**RE: DENDROBIUM MINE – PLAN FOR THE FUTURE: COAL FOR STEELMAKING (SSD 8194)
– HERITAGE COUNCIL NSW RESPONSE TO SUBMISSIONS REPORT**

Thank you for the provision of Heritage Council NSW's comments received on the Dendrobium Mine – Plan for the Future: Coal for Steelmaking Submissions Report, dated 4 March 2020.

ATTACHMENT 1
RESPONSE TO HERITAGE COUNCIL NSW COMMENTS

FIGURE 4

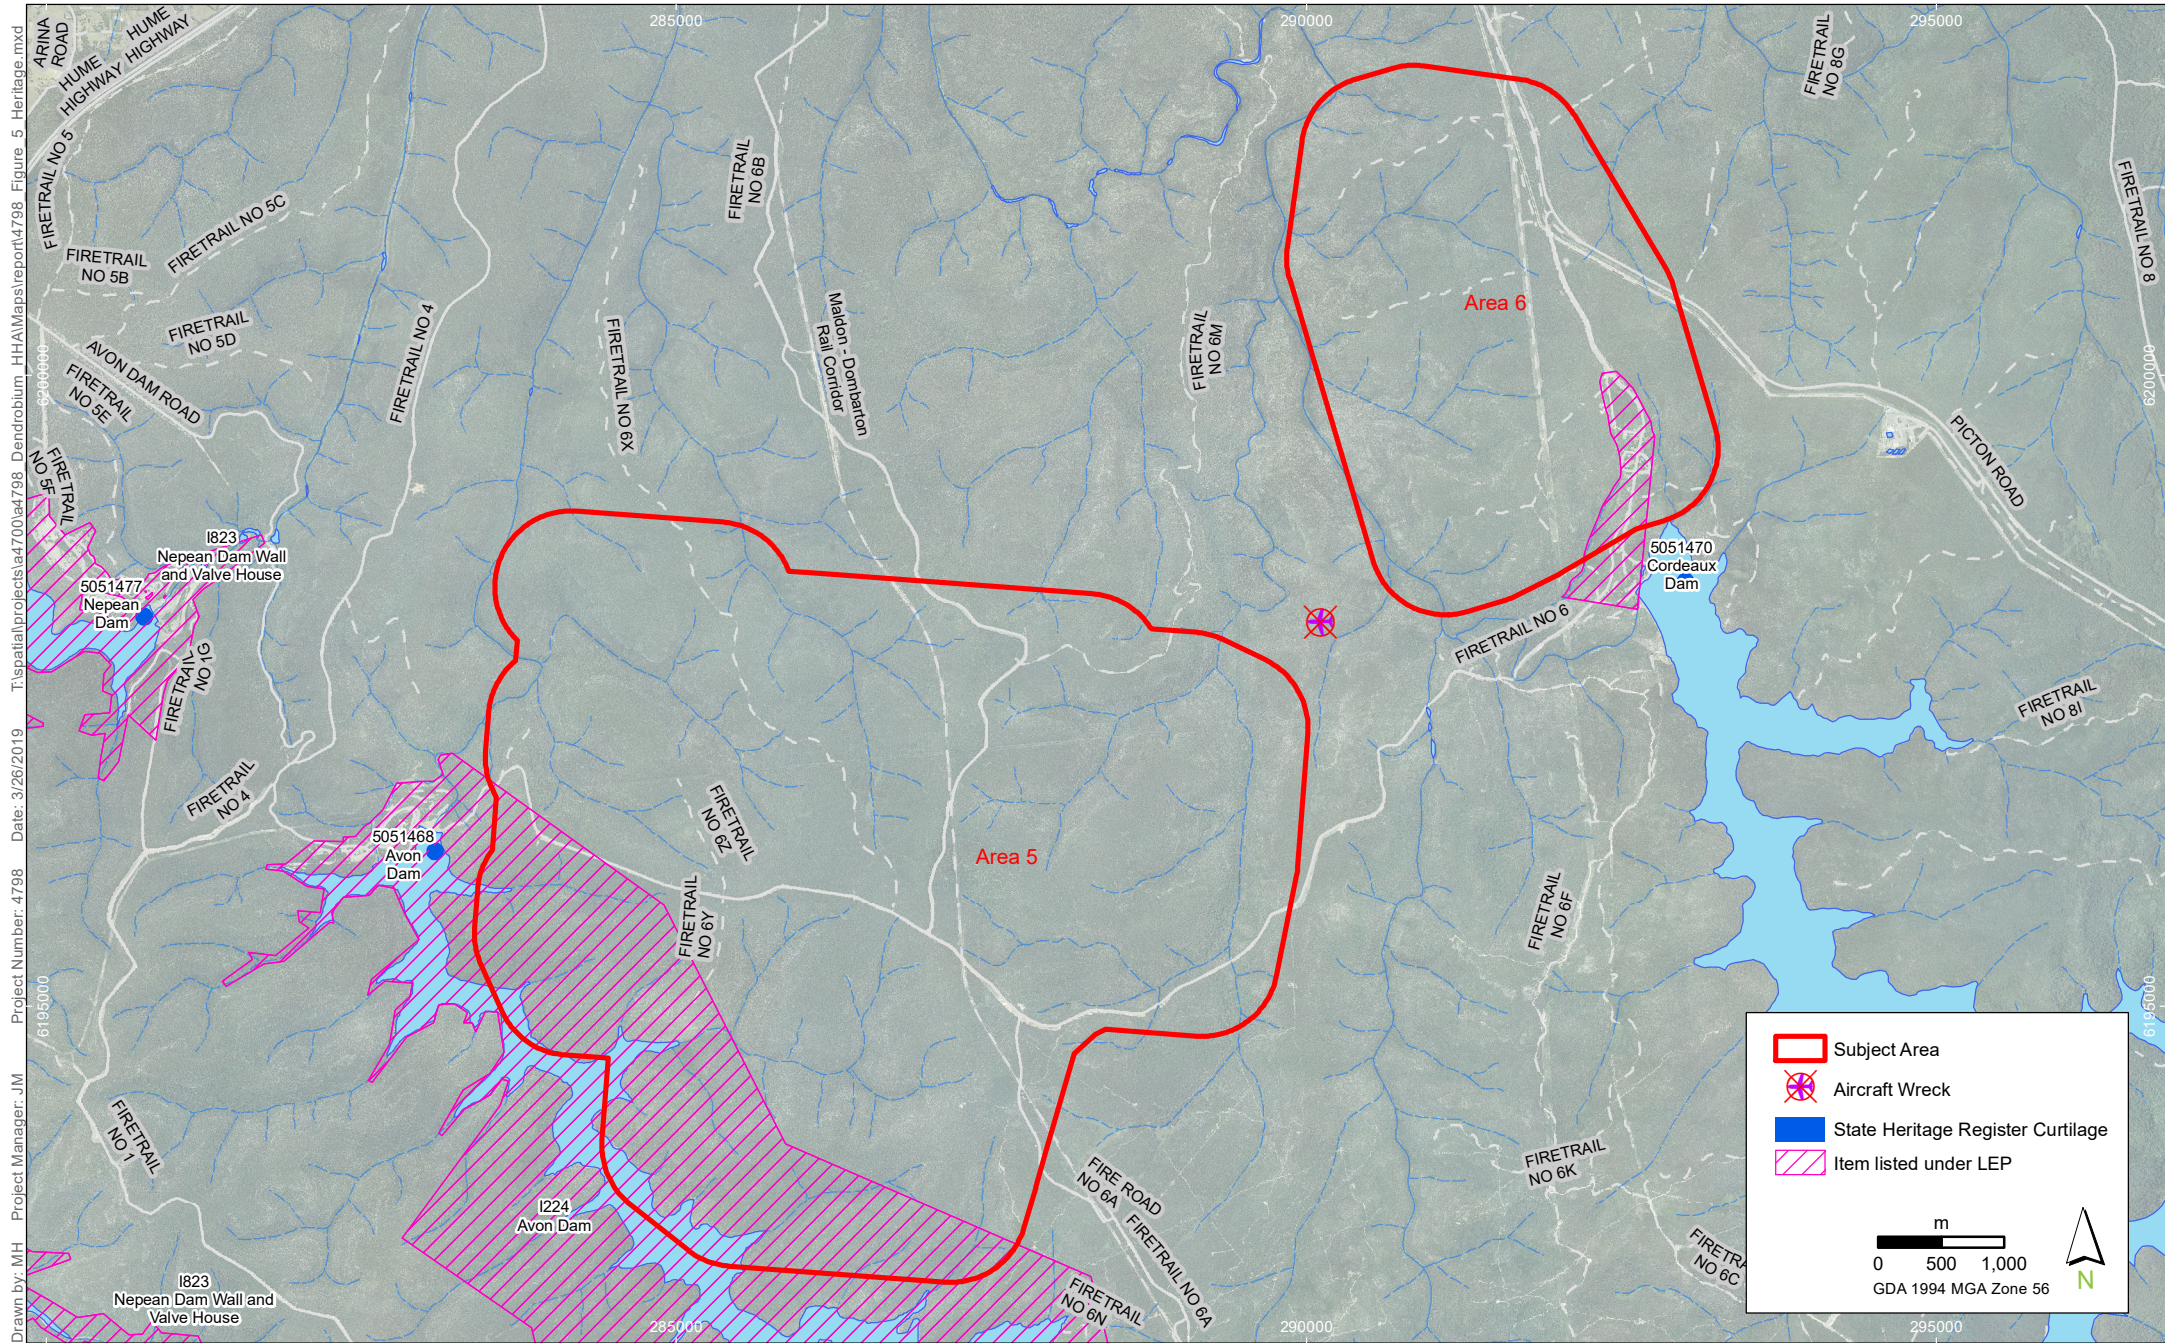
The Heritage Council requested that Figure 5 of the HHA was amended to correctly show the SHR curtilage of the Cordeaux Dam. This has not been provided in the RTS report.

Please refer to Figure 1.
